Subject: RE: Approval of details reserved by condition imposed under ref BE/66/16/PL - 182 Chichester Road, Bognor Regis - BE/60/19/DOC.

Subject: Approval of details reserved by condition imposed under ref BE/66/16/PL - 182 Chichester Road, Bognor Regis - BE/60/19/DOC.

PROPOSED ELEVATIONS

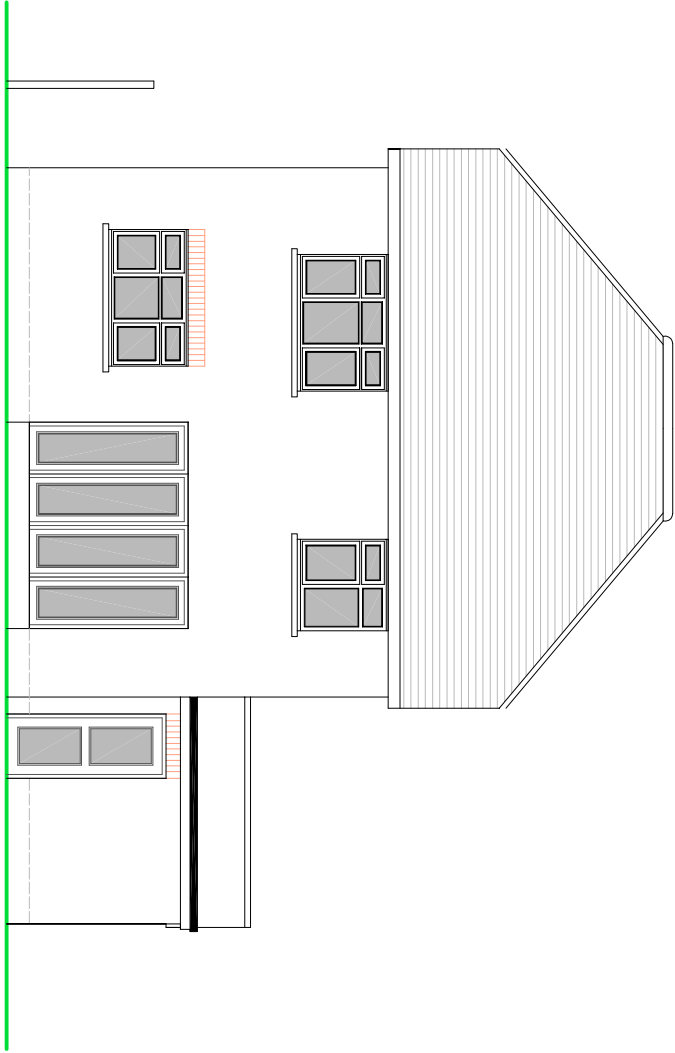
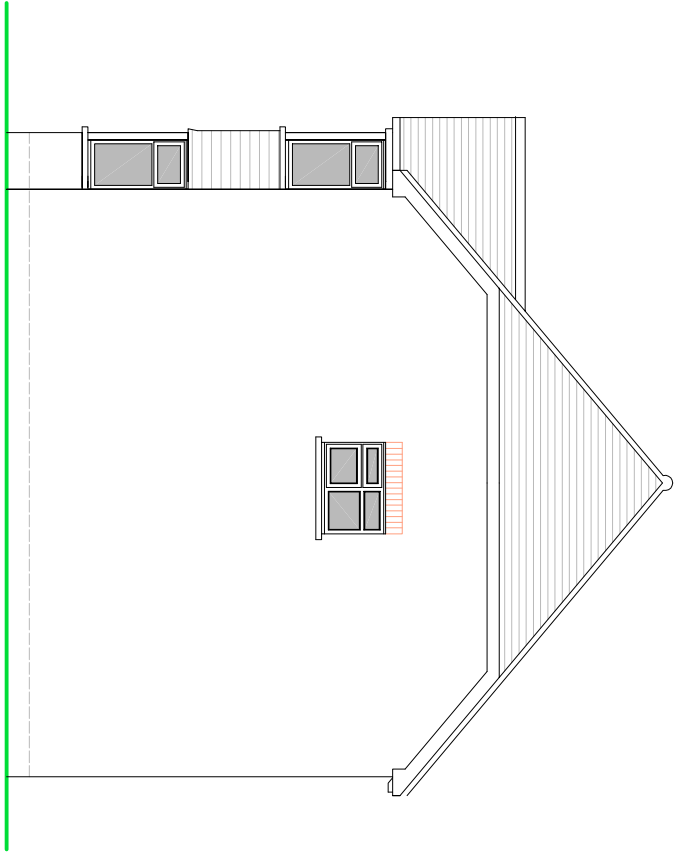
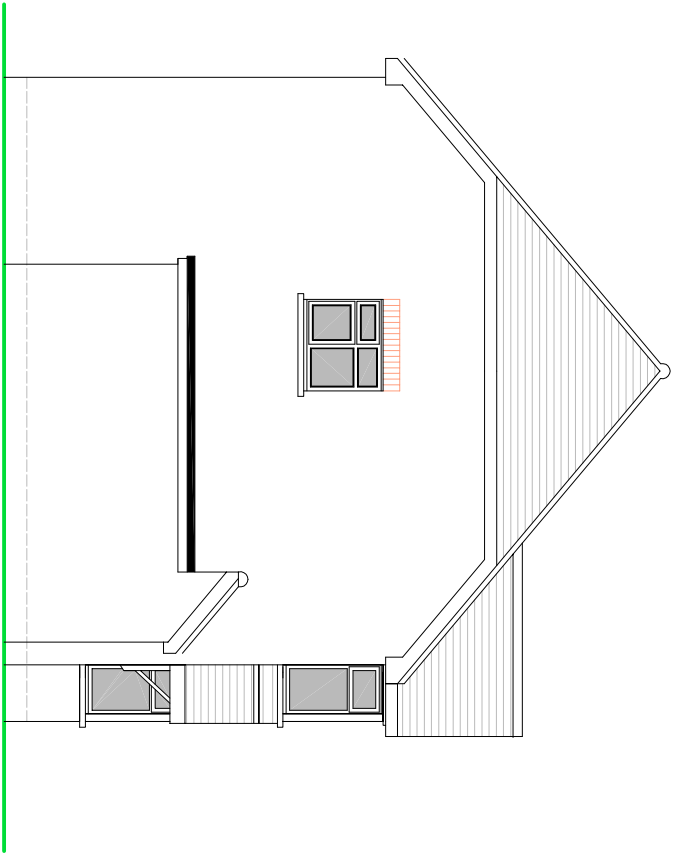
I'm still worried that the dark colour of the tile will be too much of a contrast with the reds, light red and brown tile colours of existing buildings.

On the one outstanding Condition – the finishes and materials. We were thinking of, white painted render with a grey plain tile – see attached revised elevations and picture below.
